CITY OF PORTLAND BUILDING PERMIT

PERMIT ID: 2012-65524

has permission to **21460 sf two story addition to existing building with 38 bed** provided that the person or persons, firm or corporation accepting this permit shall comply with all of the provisions of the Statues of Maine and of the Ordinances of the City of Portland regulating the construction, maintenance and use of the buildings and structures, and of the application on file in the department.

Proposed Use: Same: Long Term and Extended Care Facilities	Proposed Project Description: 21460 sf two story addition to existing building with 38 bed
--	--

Drawing file: Drawings / A0.1 First Floor Plan smoke barrier.pdf

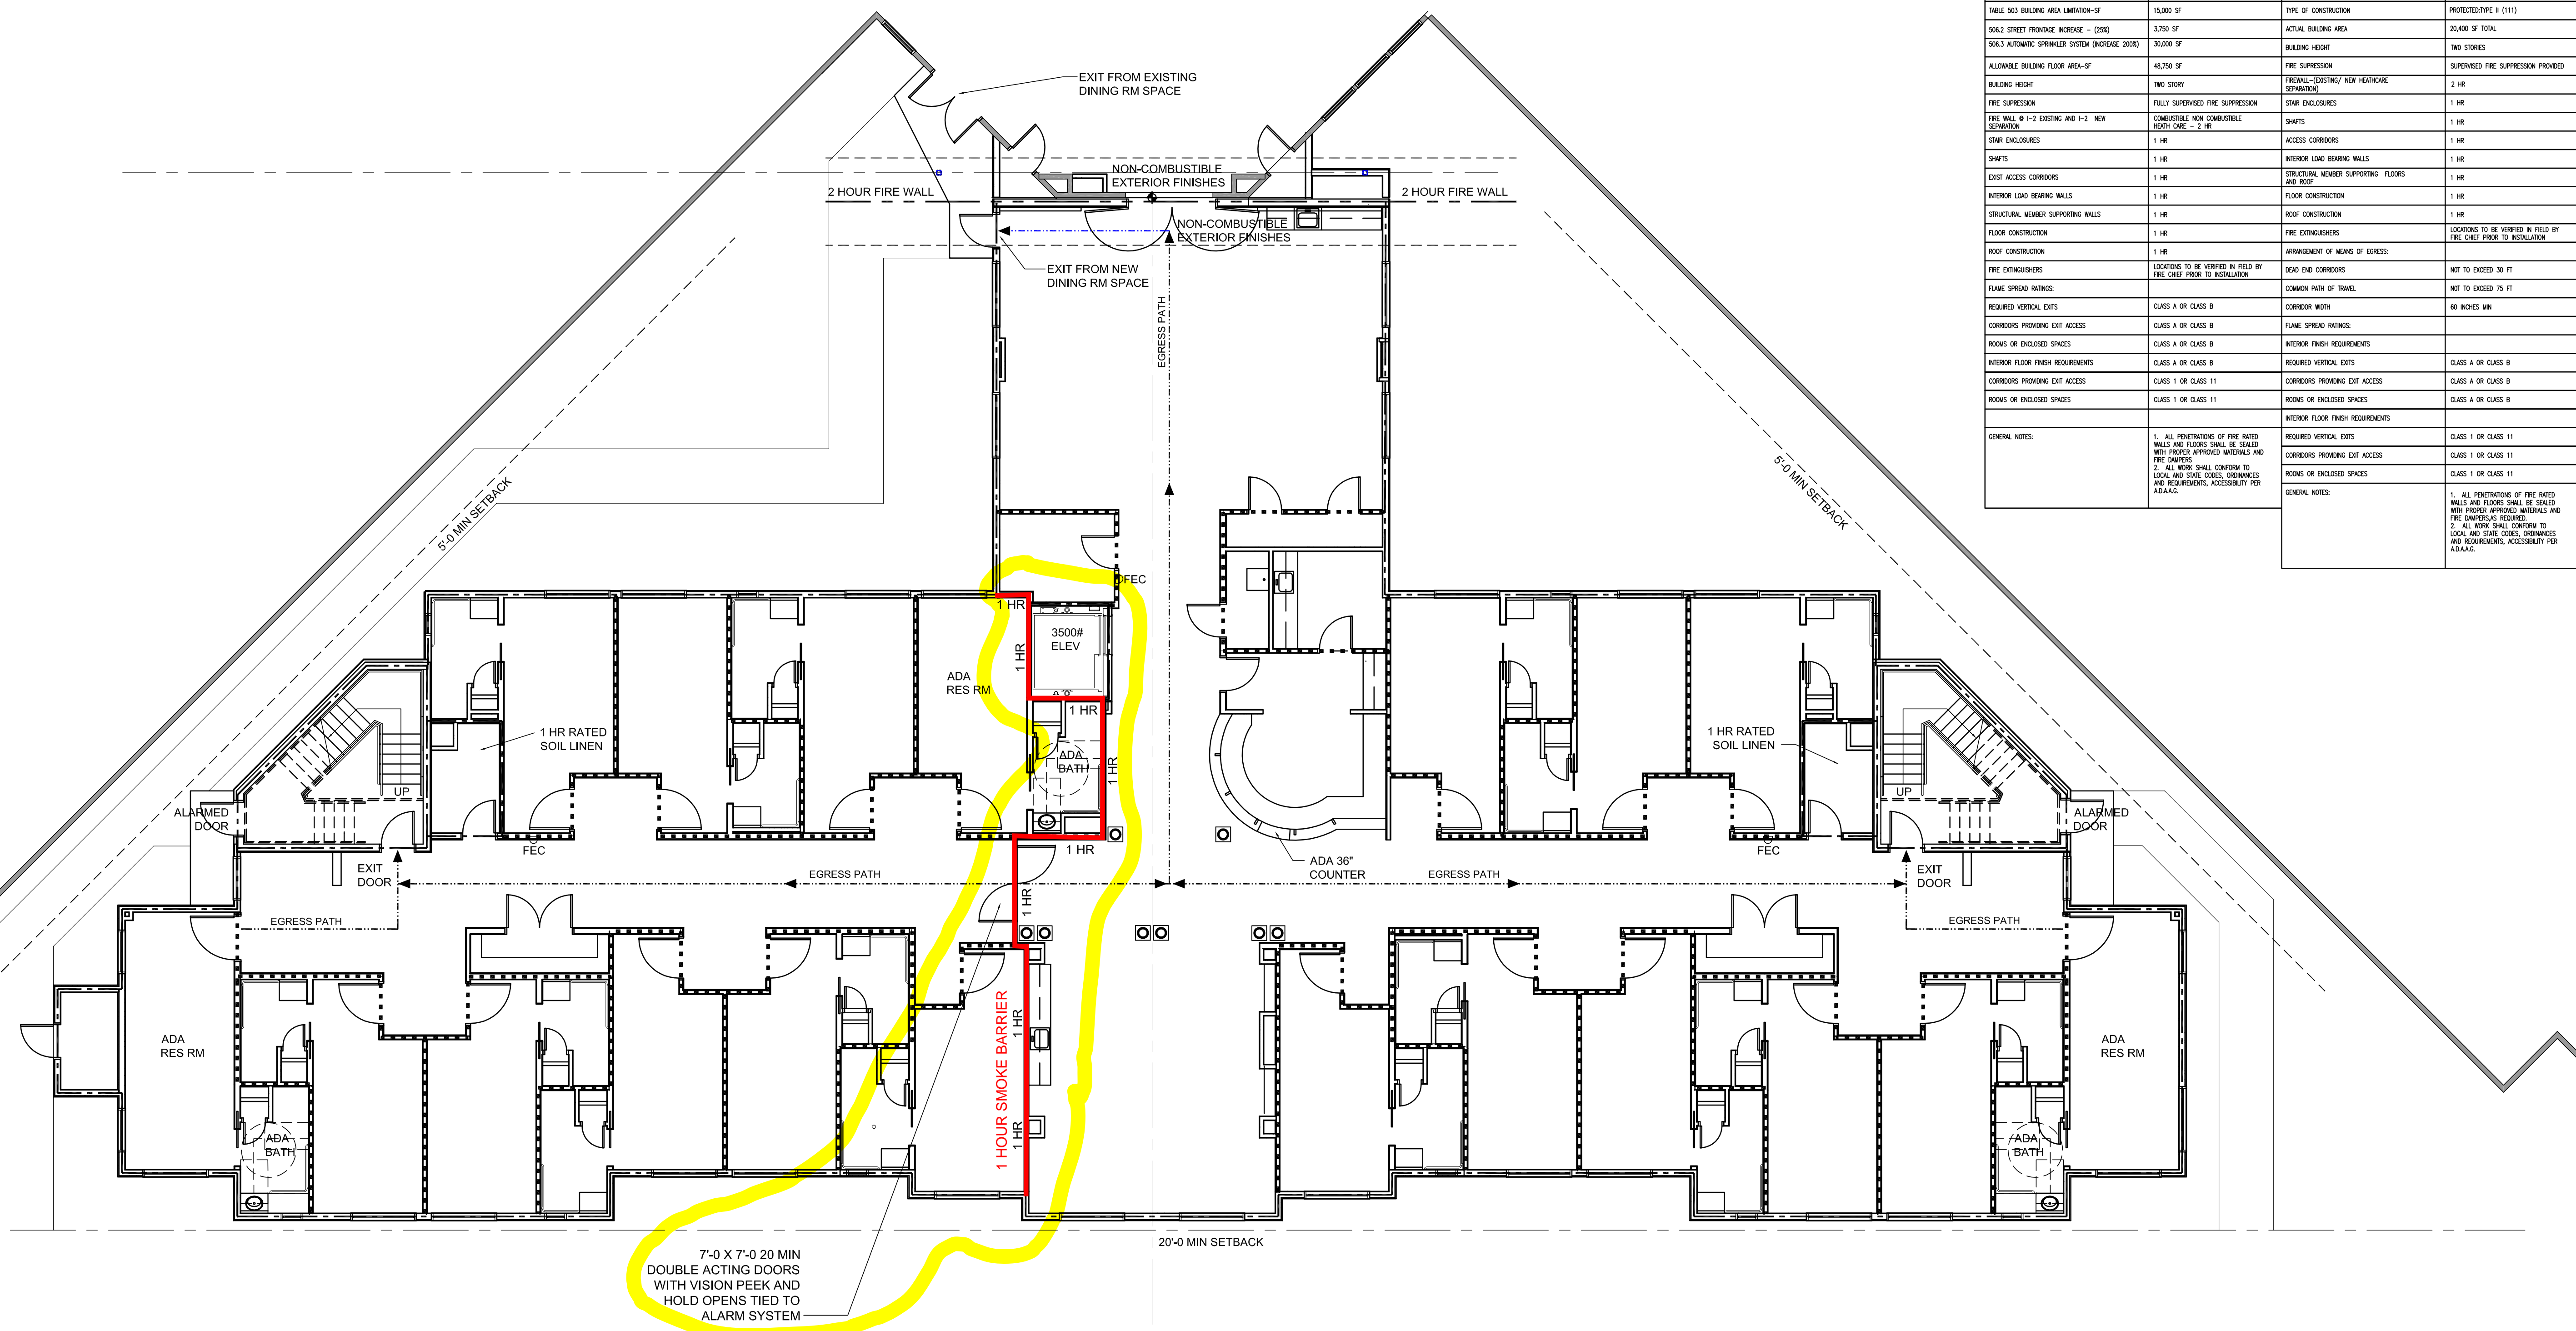
- 3) The design details for the smoke barrier wall type shall be submitted to this office for the permit record.
- 4) Application approval based upon information provided by the applicant or design professional. Any deviation from approved plans requires separate review and approval prior to work.

A special inspections report will be required for all firestopping systems.
- 2) Each floor shall be subdivided into two smoke compartments in accordance with NFPA 101:18.3.7. SKs and details are to be approved and issued prior to construction.
- 3) Fire extinguishers are required per NFPA 1.
- 4) All new smoke detectors shall be photoelectric.
- 5) Inspection, testing, and maintenance of fire alarm equipment shall be in accordance with NFPA 72.

Drawing Name:
 Foundation Plan

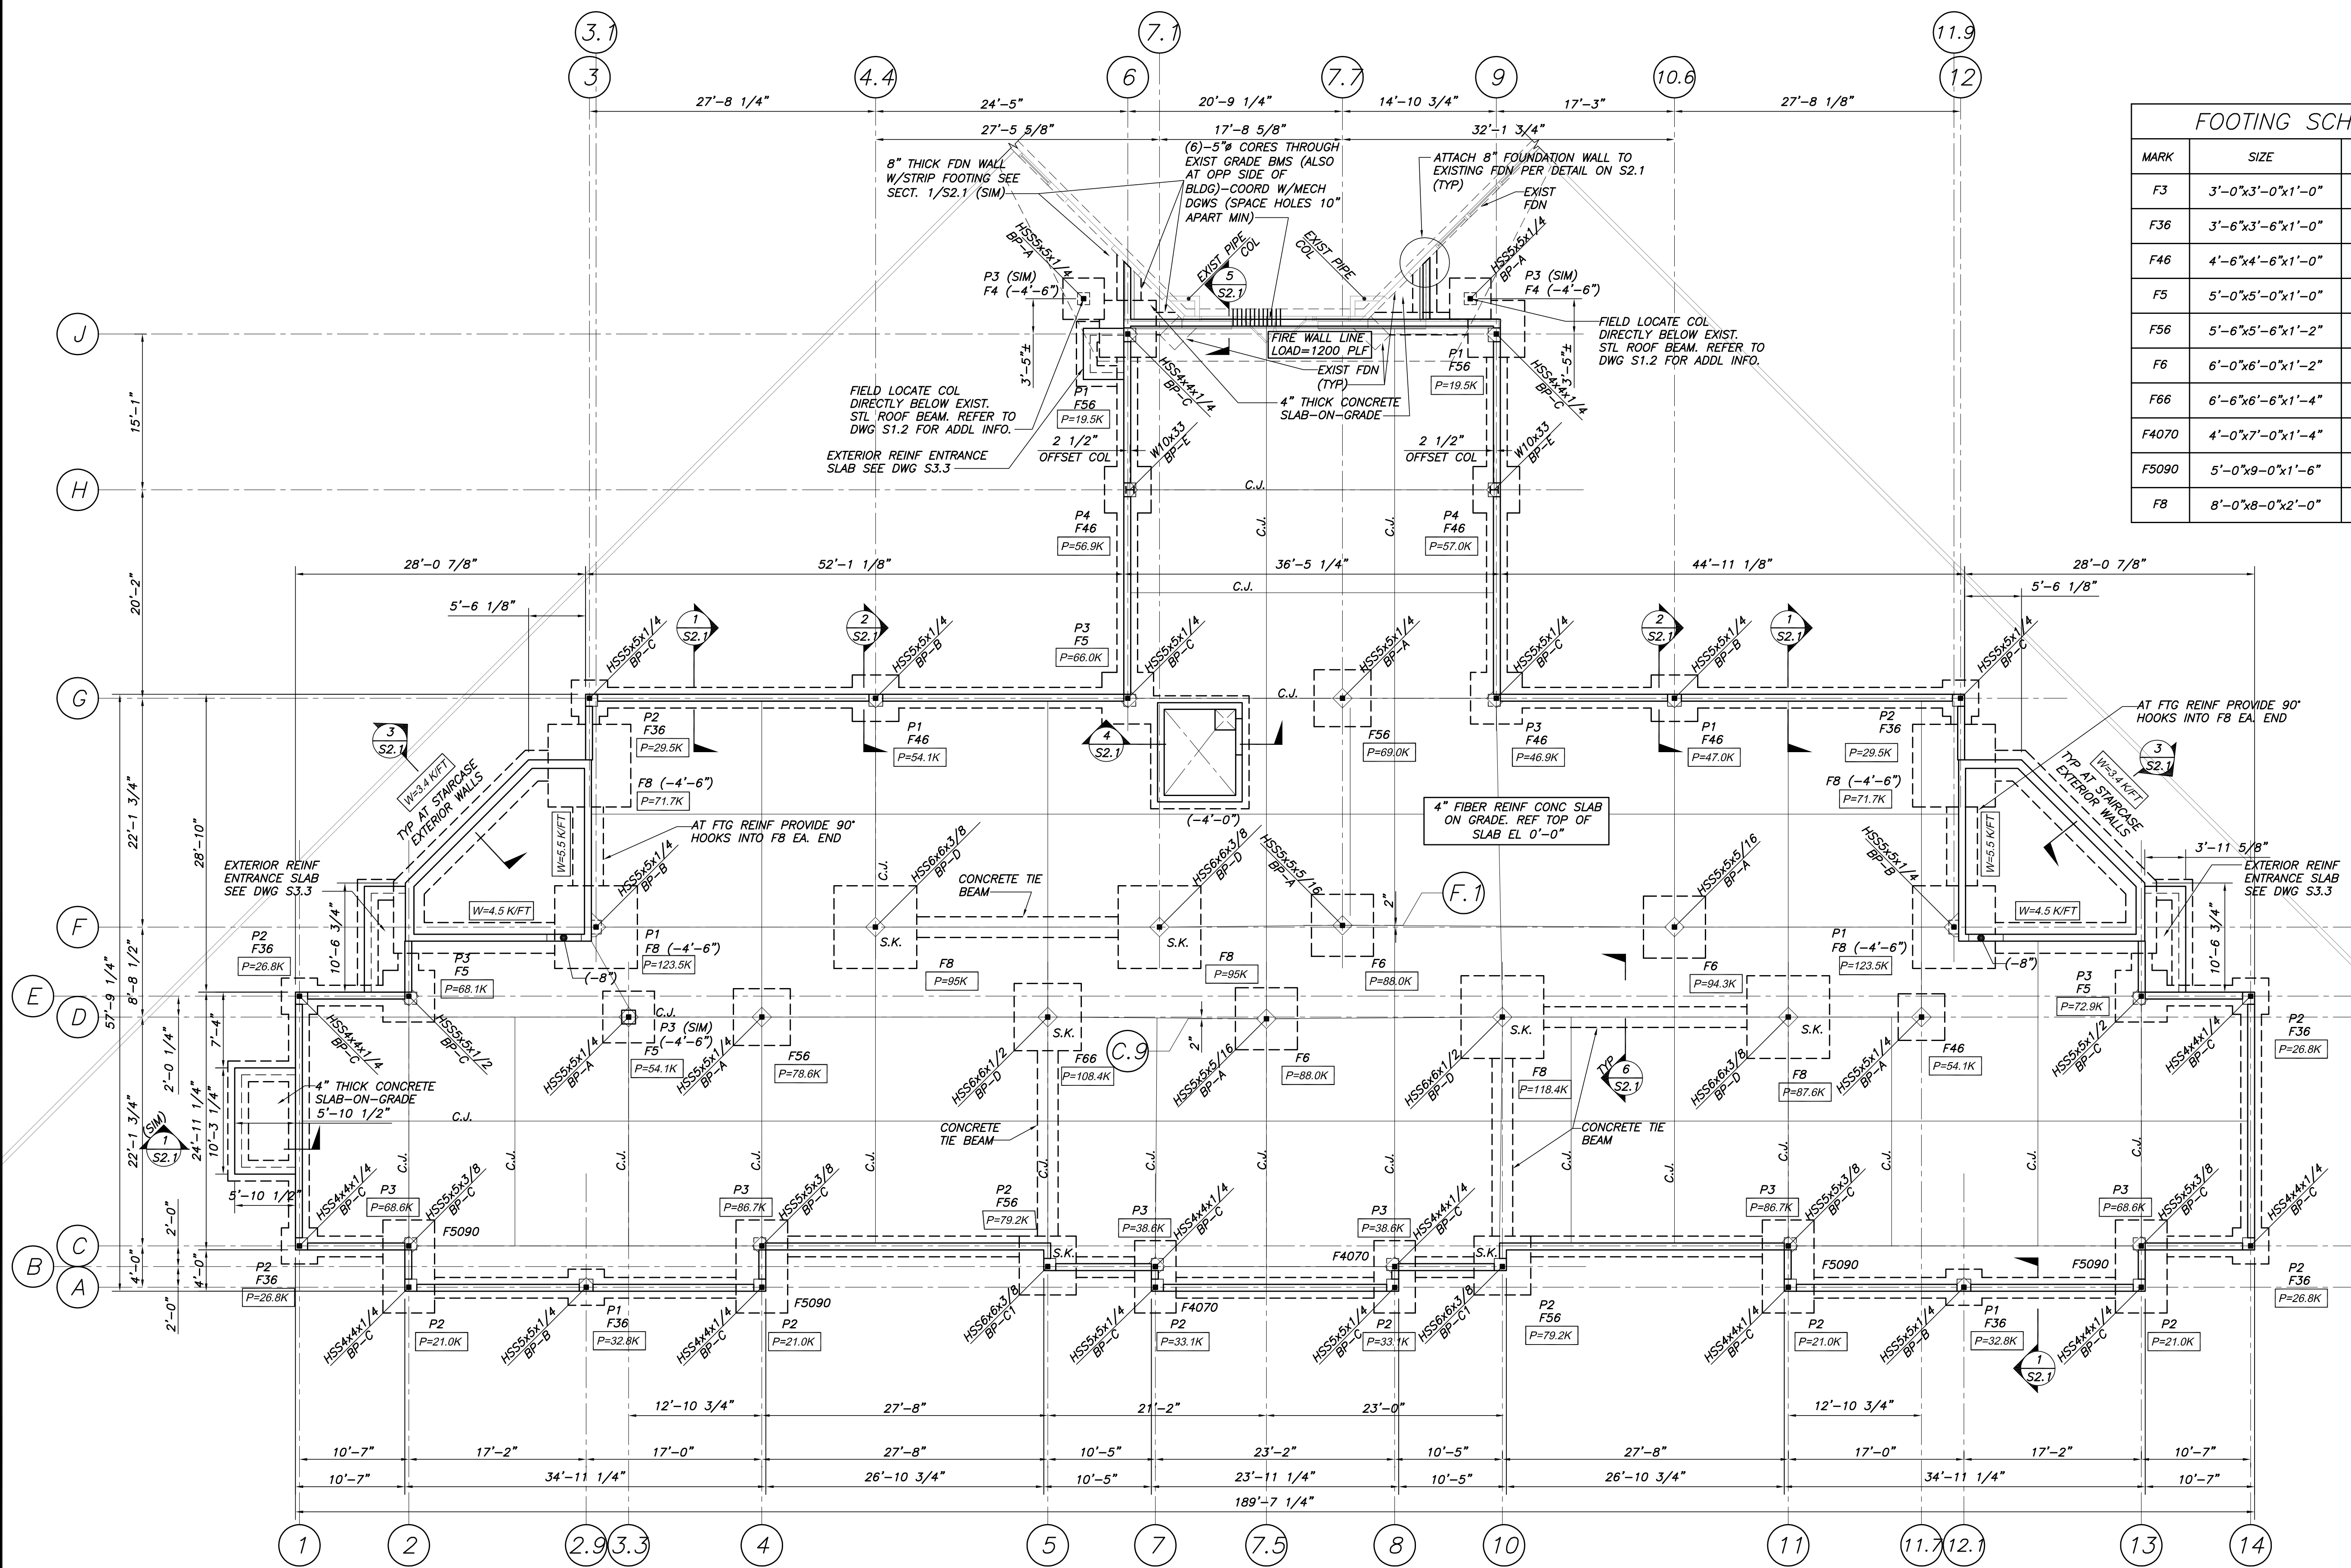
- 6) Complete updated construction plans shall be submitted electronically as soon as they become available
- 7) Provide design specifications and construction plans for the Aggregate Pier ground improvement per the Specifications Manual Part 3, 3.02. Contact is Jeanie Bourke at jmb@portlandmaine.gov, 874-8715.
